Town & Country Planning Act 1990 (as amended)
Town and Country Planning (Development Management Procedure) (England) Order 2015
Approval of details reserved by condition imposed under ref Y/146/20/RES relating to Condition No 5 -
full details(materials/appearance) of any required works to flint wall along North End Road frontage.
Land at Street Buildings North End Road Yapton BN18 0DT

Condition Number 5

Arun District Council have decided to **APPROVE details reserved by this condition**

Development	YAPTON		
Location	NORTH_END_ROAD_YAPTON		
Marketing Name			
Drawing Title	LOW_FLINT_WALL		
Drawing Number	783-DET-002		
Revision	-	Scale @ A1	1:10_&_1:200
Drawn By	SK	Date Started	24.05.2021
Checked by		Date

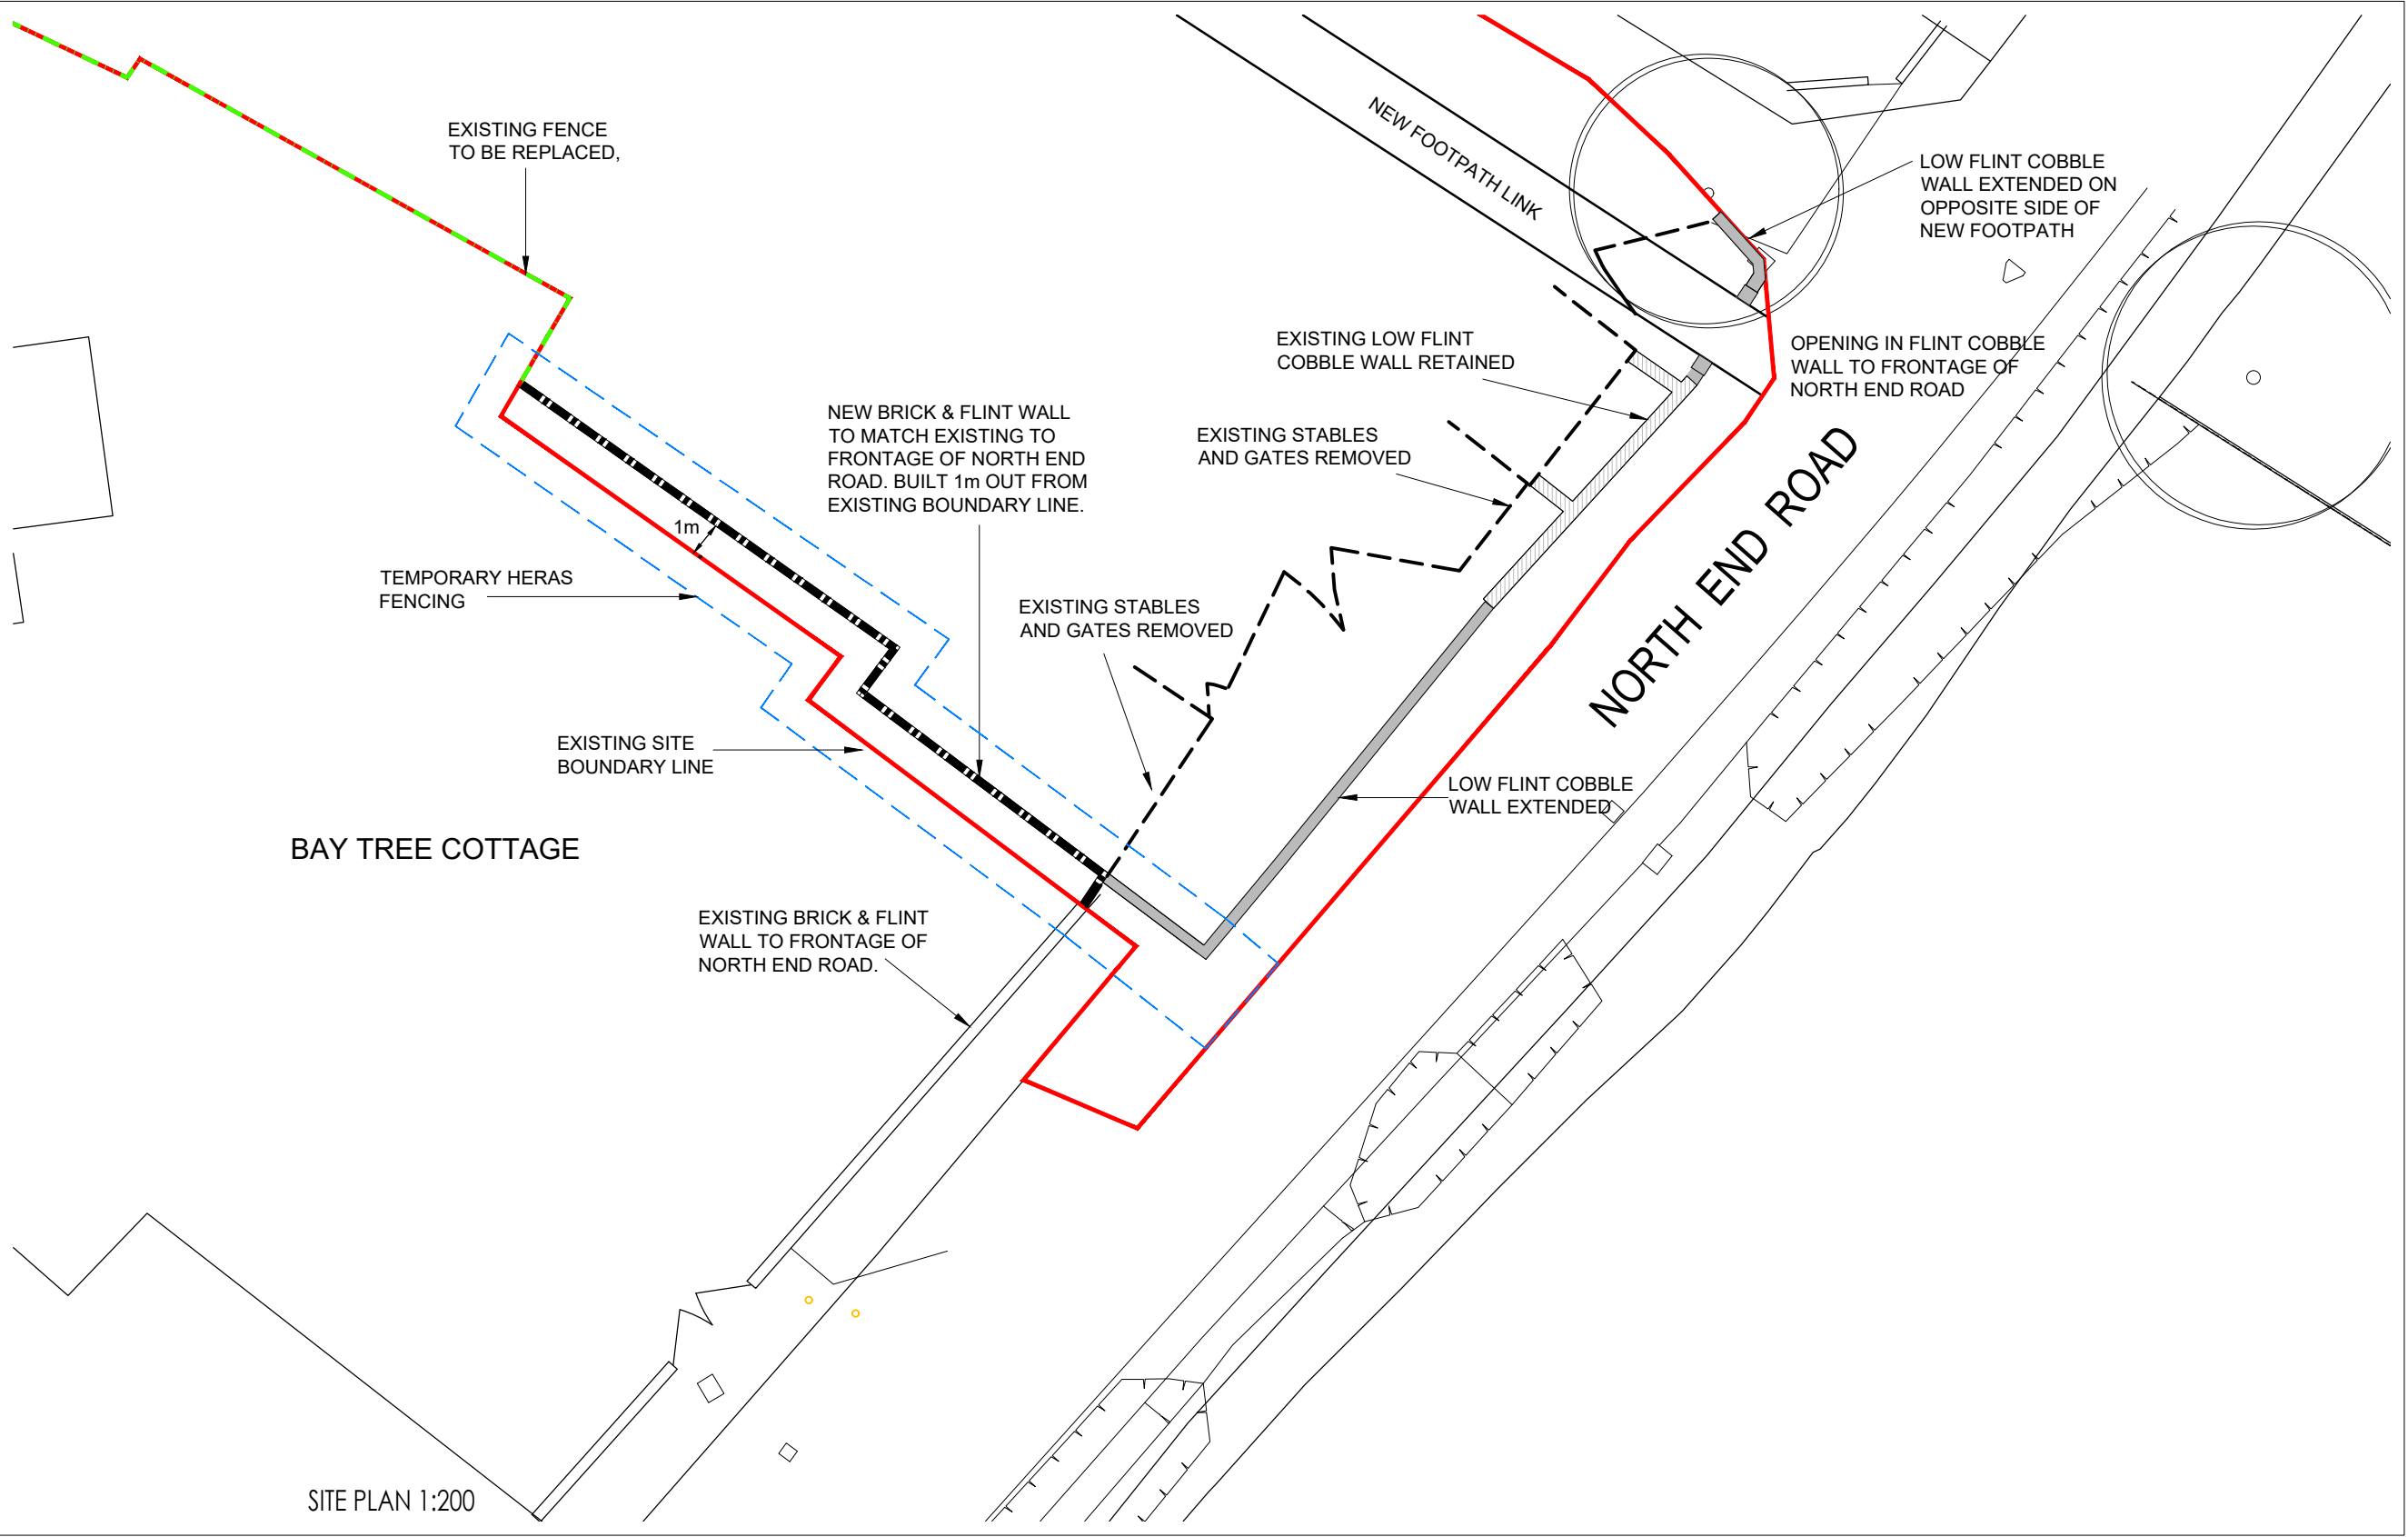
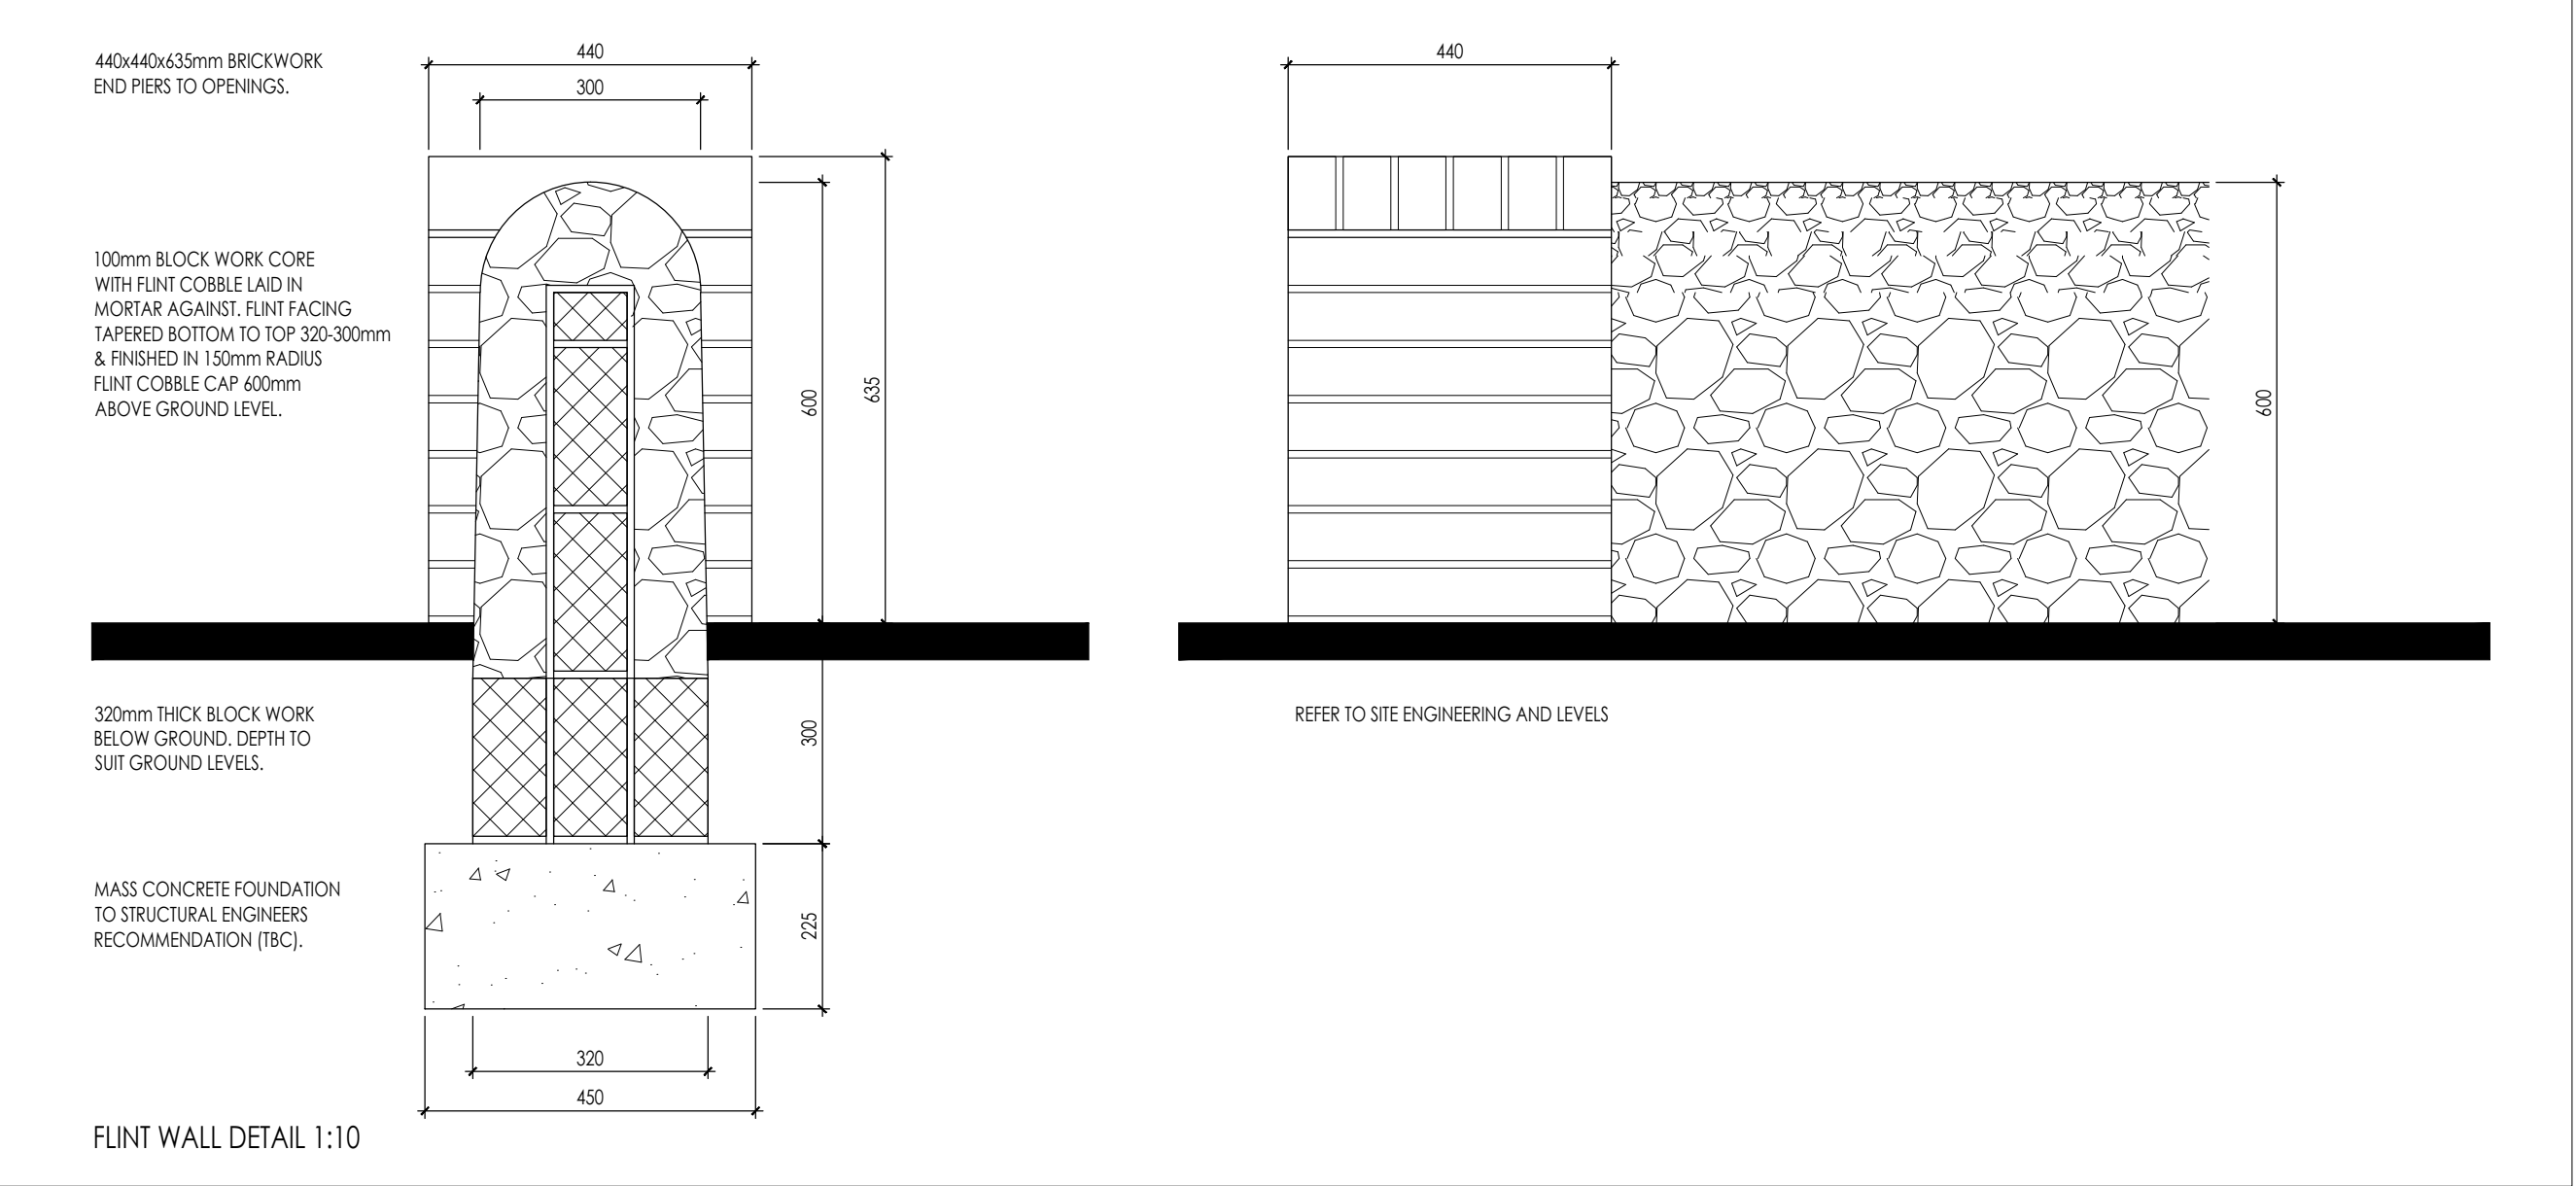
You have provided a revised version of Dwg 783-DET-002 "Low Flint Wall" (as submitted by email 22/07/21) which shows how the existing flint cobble wall will be extended along the frontage. The details have been agreed with our Conservation Officer and we are able to now discharge the condition albeit on the condition that the changes to the wall are completed in accordance with the approved details prior to occupation of any of the approved houses.
